The Sizewell C Project

6.3 Volume 2 Main Development Site Chapter 12 Air Quality Figures 12.1 - 12.2

Revision: 2.0
Applicable Regulation: Regulation 5(2)(a)
PINS Reference Number: EN010012

Revision history / Record of comments

DRAWING NO:
 FIGURE 12.1

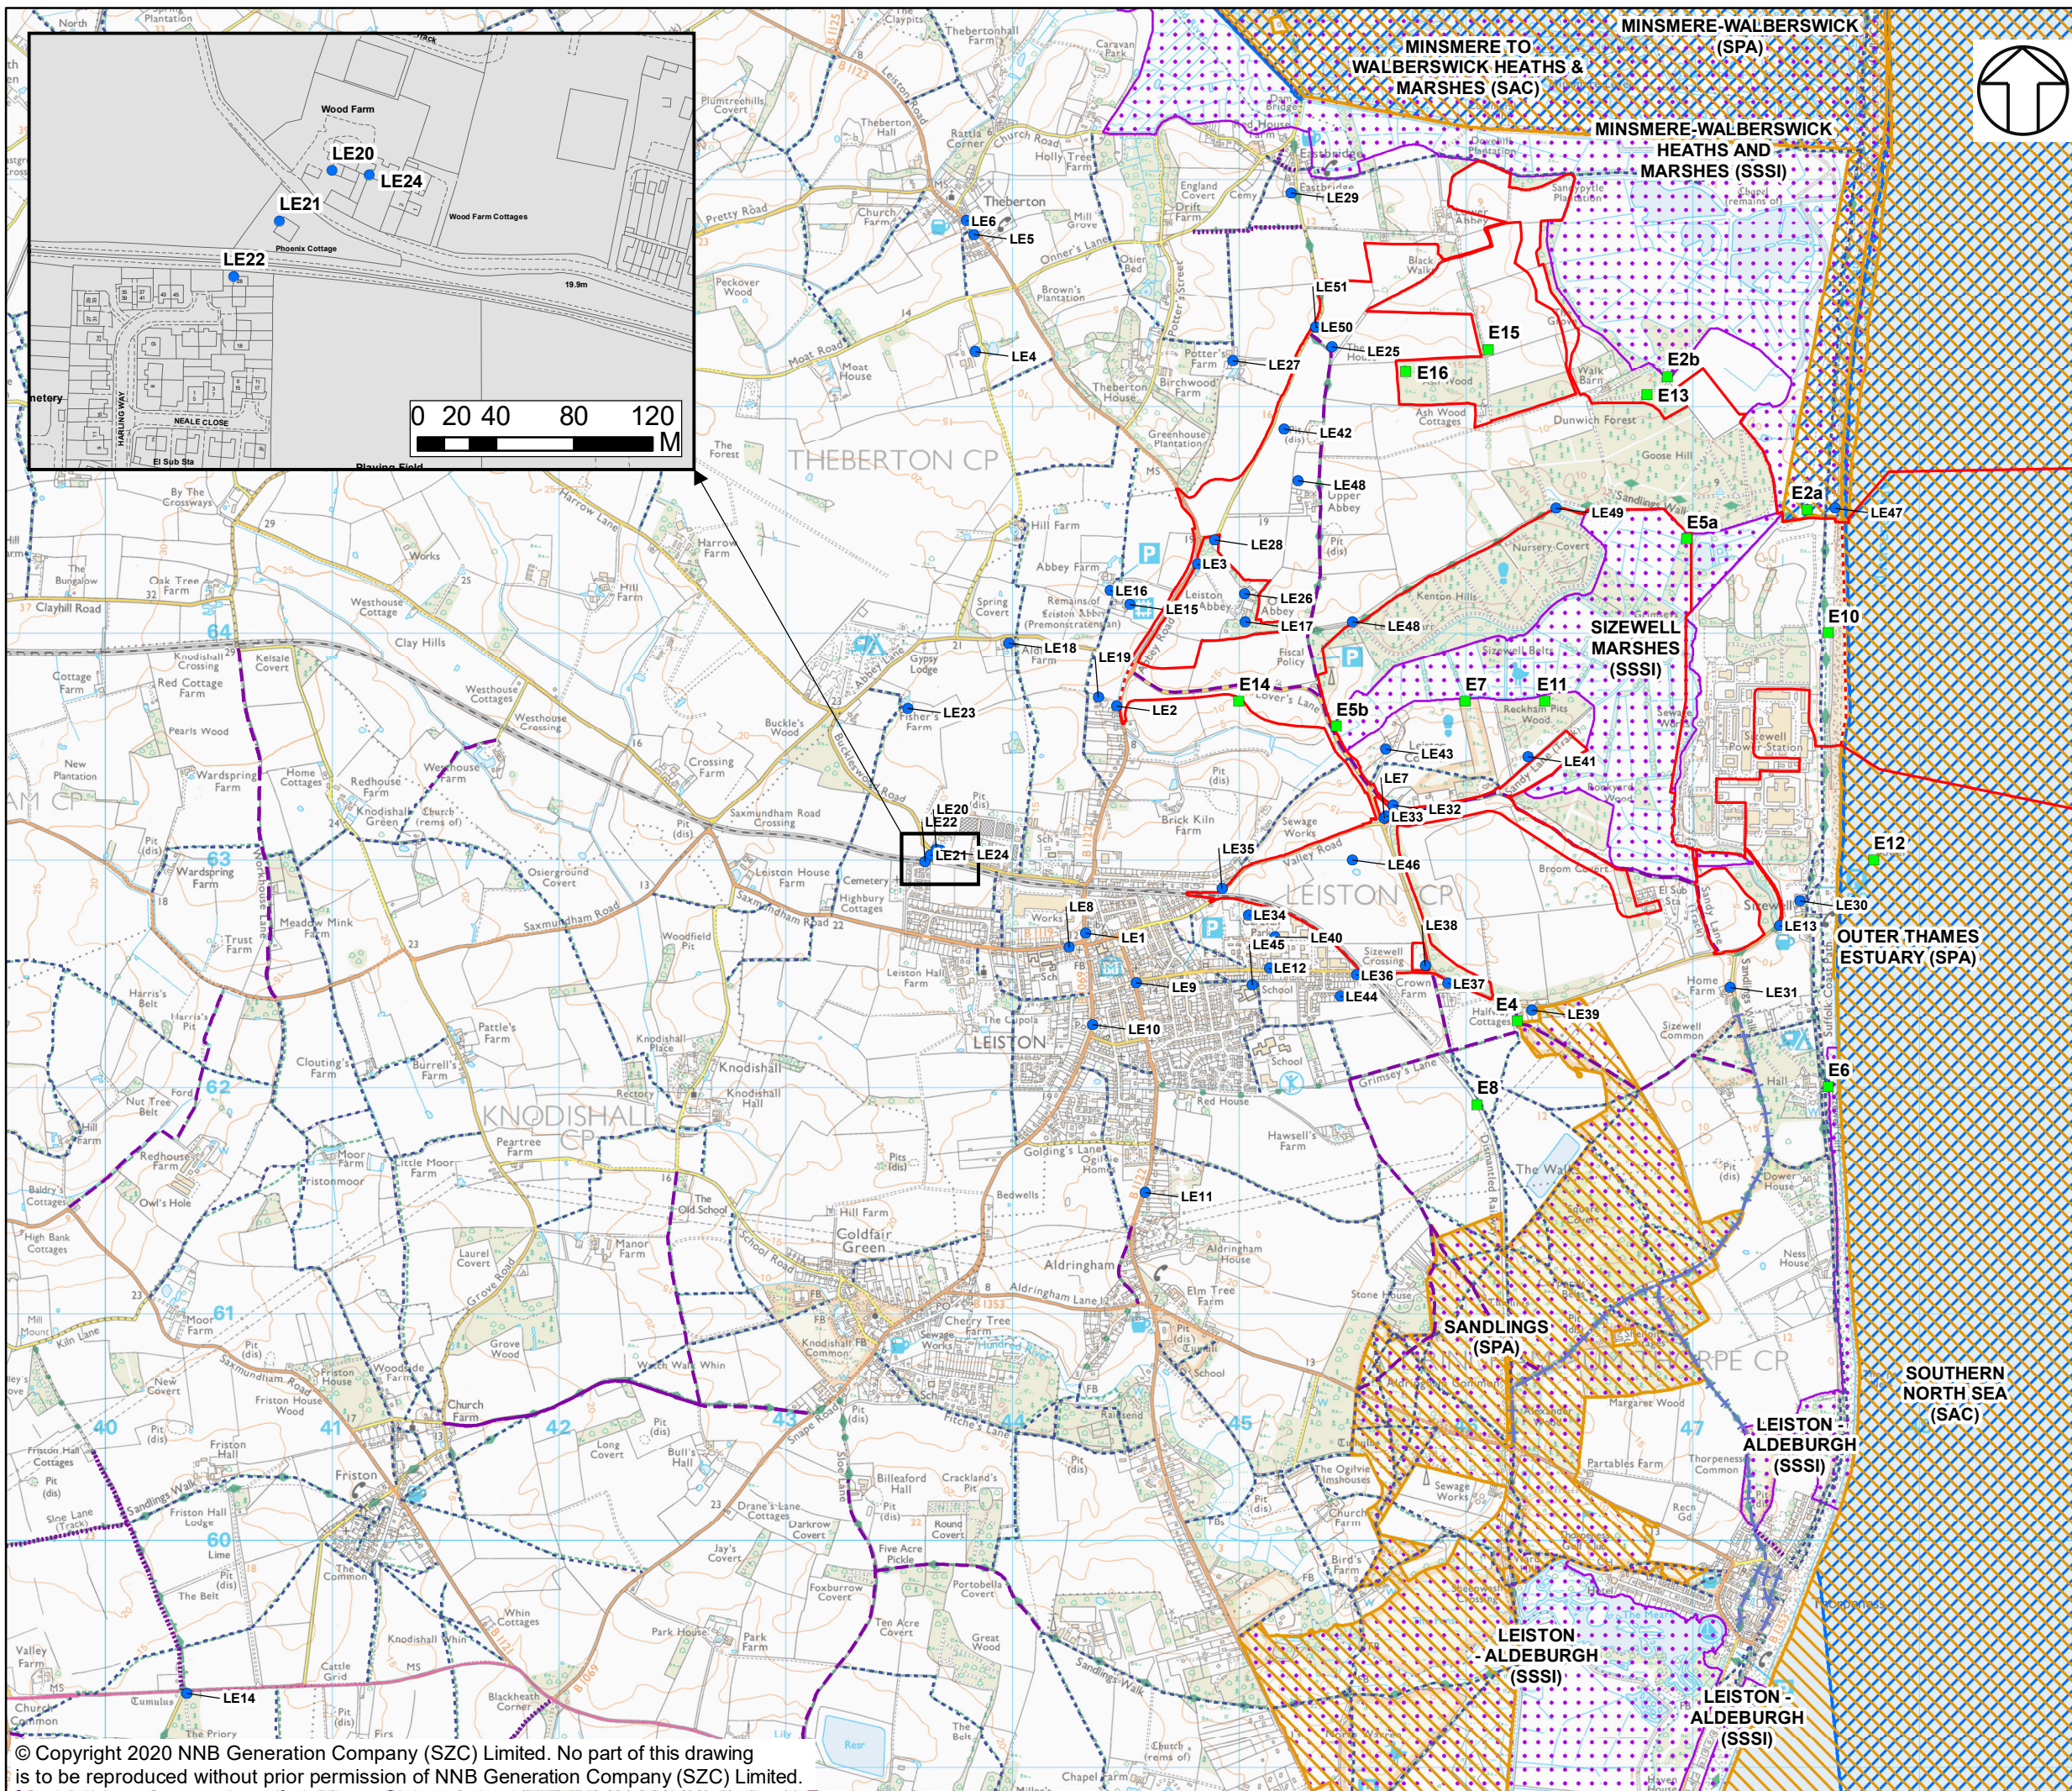
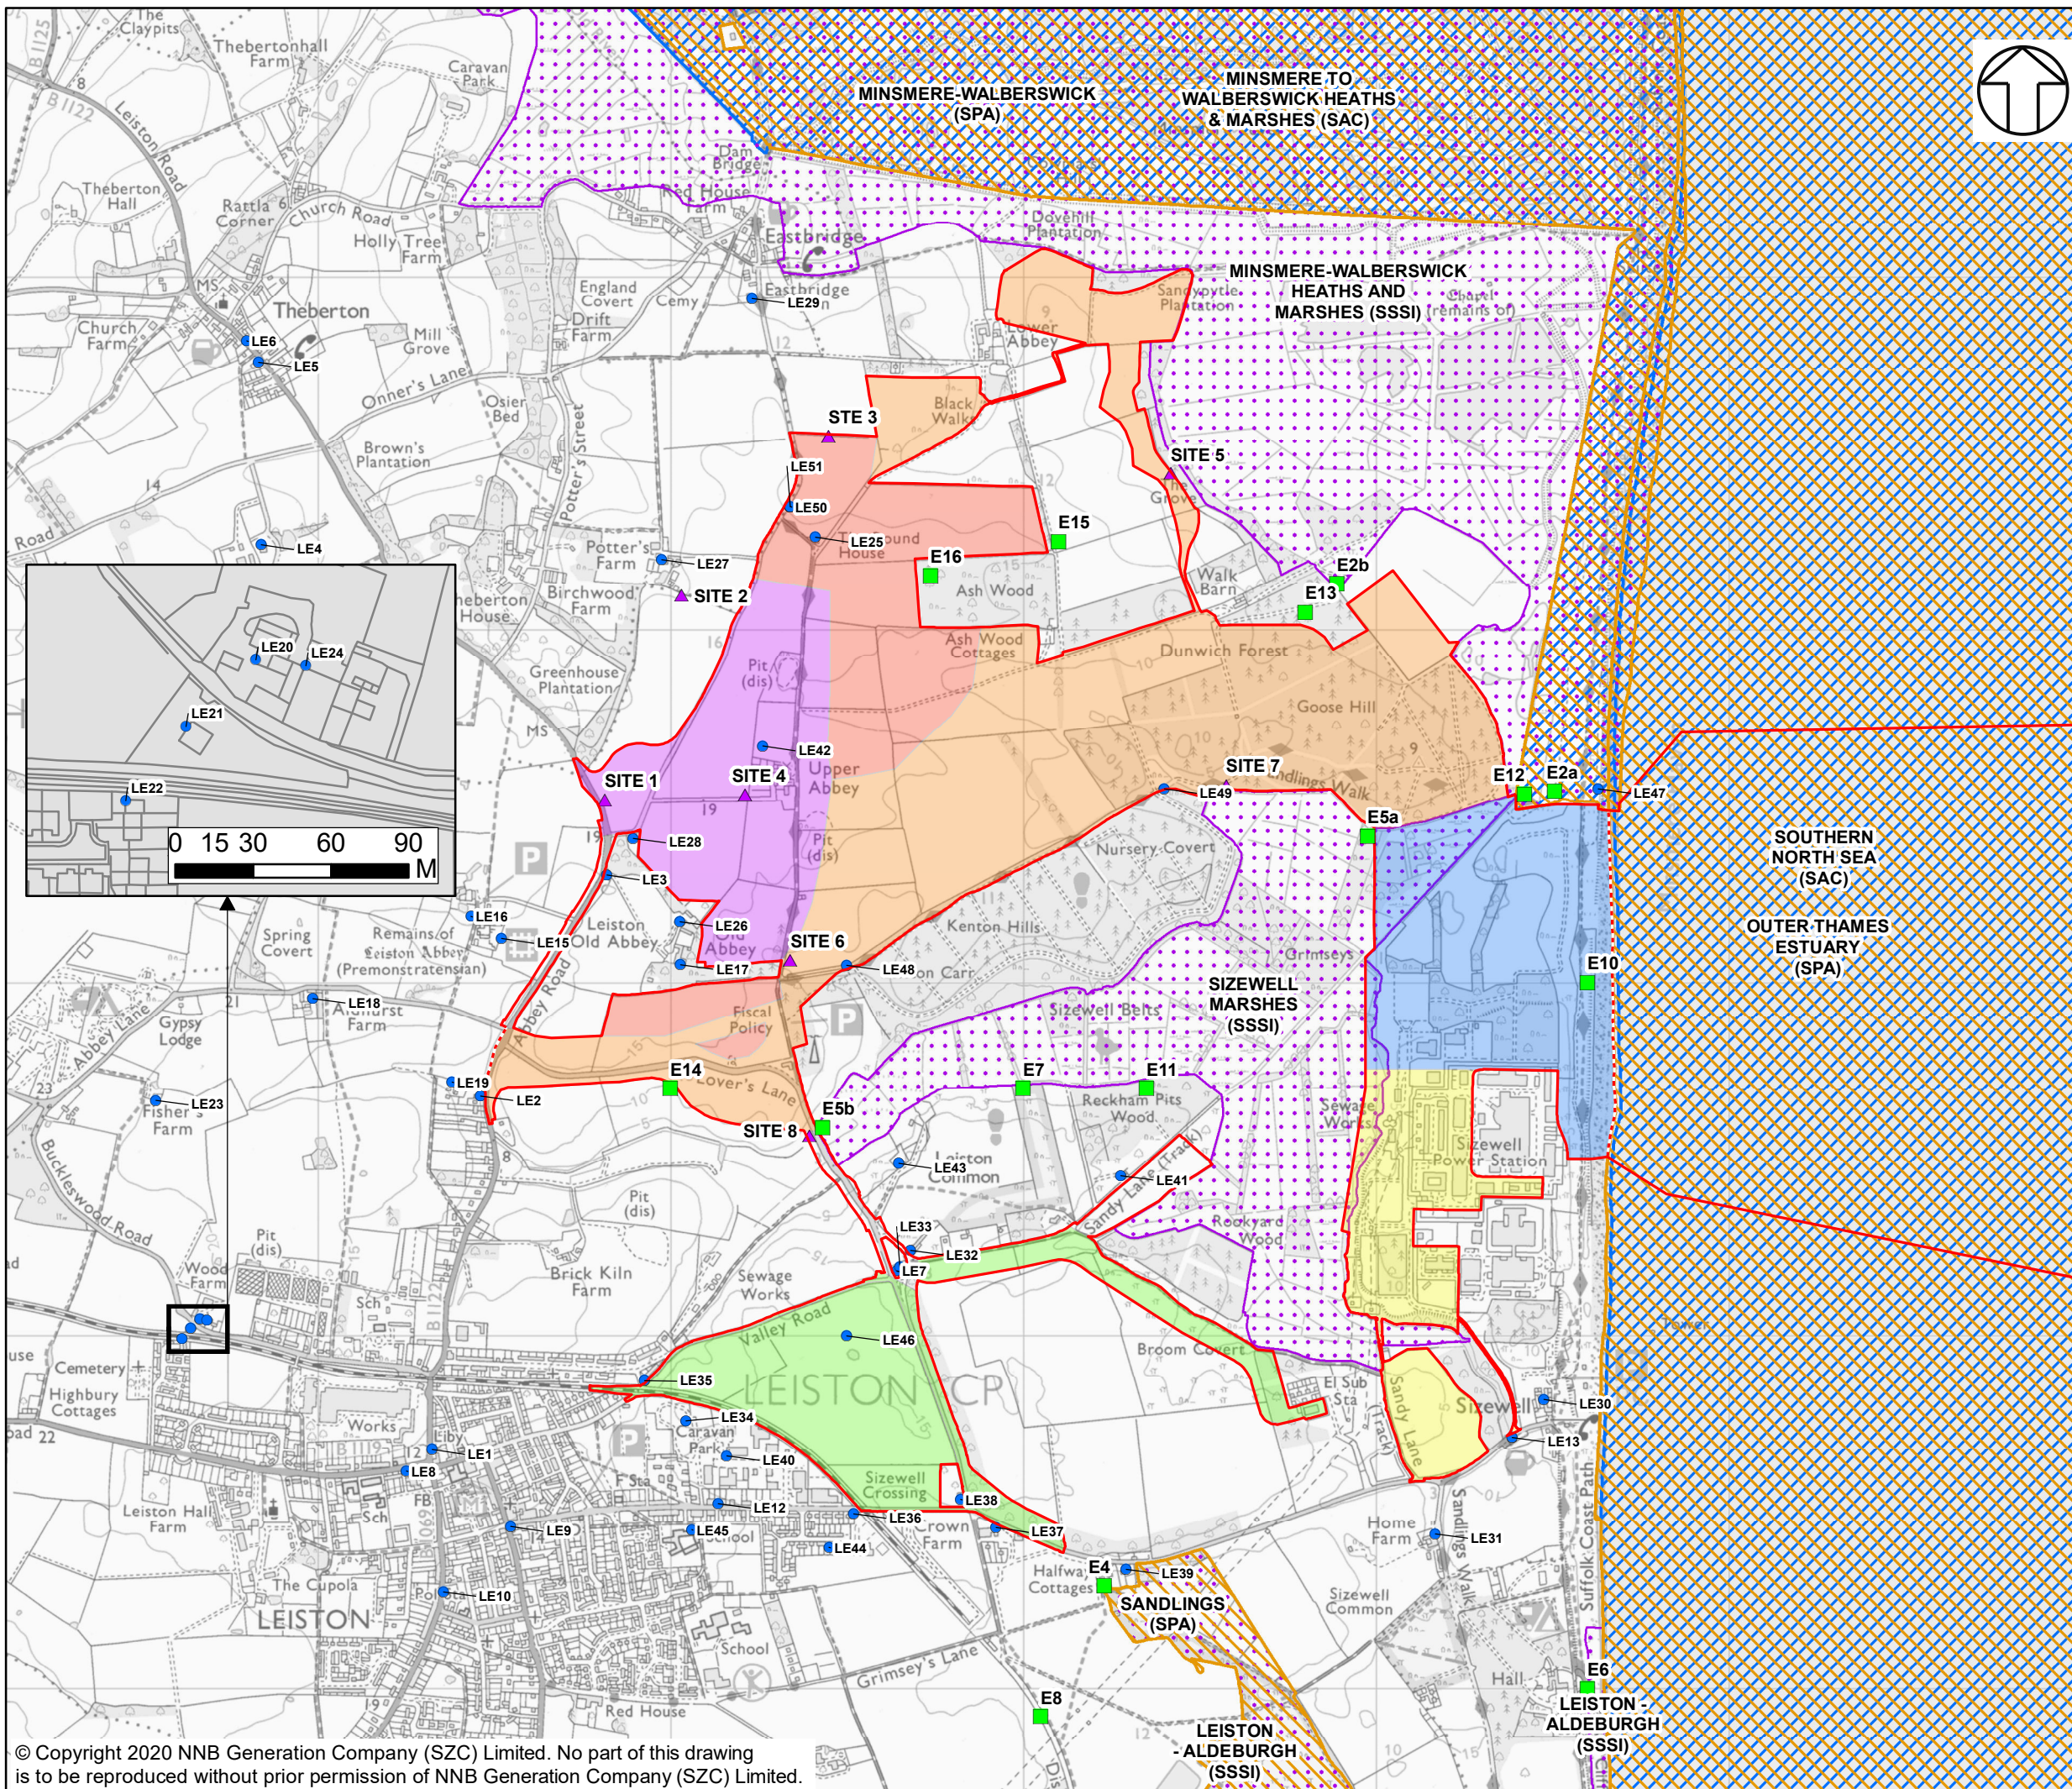
Revision	Amendment	By	Date
01	Original version [APP-215]	SZC Co.	May 2020
02	Figure 12.1 – Errors to labelling corrected Figure 12.2 – No change	SZC Co.	November 2020
